MODULE 2 PRESENTATION TO METROLINK ORAL HEARING 19/03/2024

District 7 Community Alliance

MATER STATION

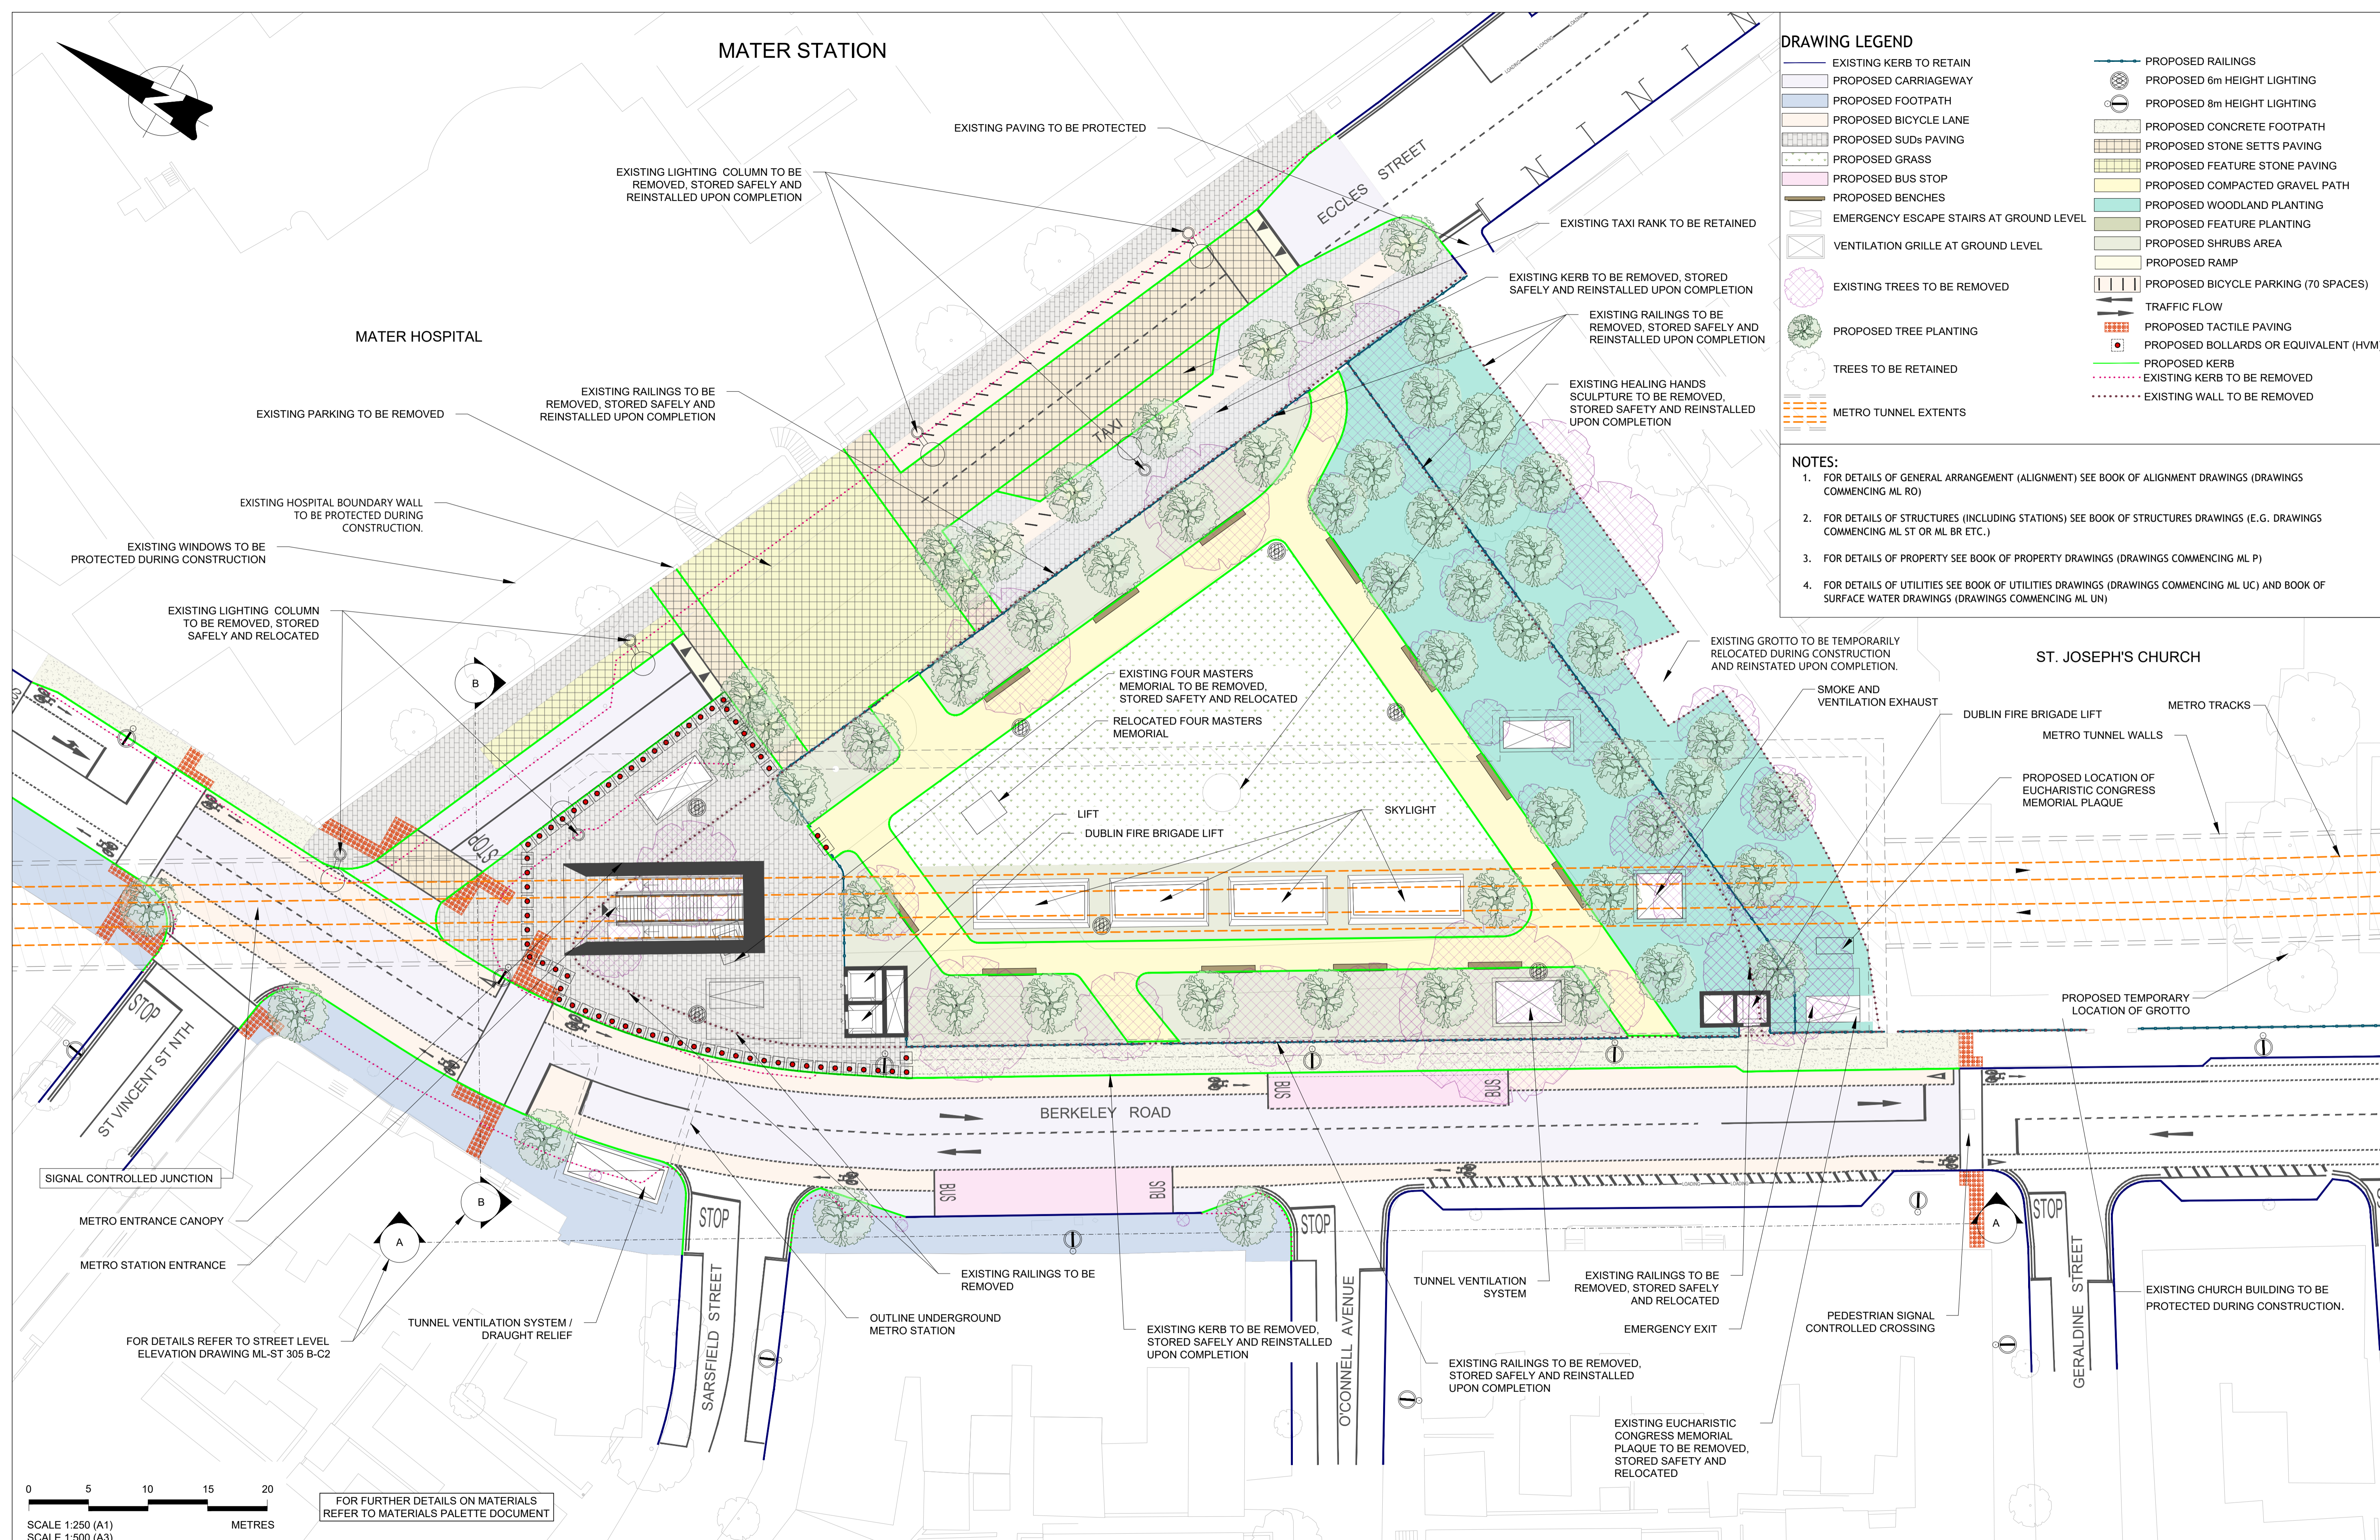
[SLIDE 4] This enclosed park is now to be replaced by an open paved plaza with a much-reduced park behind (up to 50% of green space will be lost), allowing public access to it day and night with all the attendant dangers of anti-social behaviour. It will be dominated by the station canopy a design which ignores entirely the historical and cultural aspects of the park it will be replacing.

[SLIDE 5] TII state that they are reinstating the Four Masters Park and that only 10% is being taken by the Mater station canopy. However this calculation does not include the Dublin Fire Brigade lifts or the proposed skylights and other overground buildings. [SLIDE 6] TII say they are reducing the size of the skylights, but we have seen no proposed design and nothing in writing to this effect.

The proposed bollards are also out of character with the area and would be better

We therefore request that the overground structures in the park, in particular the skylights, be eliminated or at the minimum reduced in bulk.

Unlike other MetroLink stations with a canopy design, the canopy and the Dublin Fire Brigade lifts at the Mater Station are situated on a very small site which is surrounded by buildings, the small site makes the canopy and Dublin Fire Brigade lifts visually dominant. [SLIDES 8, 9] The visual impact of the canopy and lifts destroys the view of the beautiful entrance to the Mater Hospital. [SLIDE 10] This building is a National Monument, its commanding portico and entrance were designed to have been appreciated from a distance not from the bottom of the steps on Eccles St.

[SLIDE 11] The heavy iron frame of the building is overbearing and will undoubtedly attract graffiti, particularly as at the site will be open 24 hours a day and the street quiet. This applies also to the glass and moreover, we understand that the glass is going to be tinted, further blocking views of the Mater Hospital entrance and surrounding streetscape. No provision appears to have been made by TII to develop a strategy to deal with graffiti; No water cleansing or water saving solutions are provided for the canopy and the large paved area around it.

We are therefore requesting a re-design of the canopy to be in more sympathy with the surrounding landscape and that the Dublin Fire Brigade lifts be clad in a more sympathetic material such as red brick to make them less intrusive.
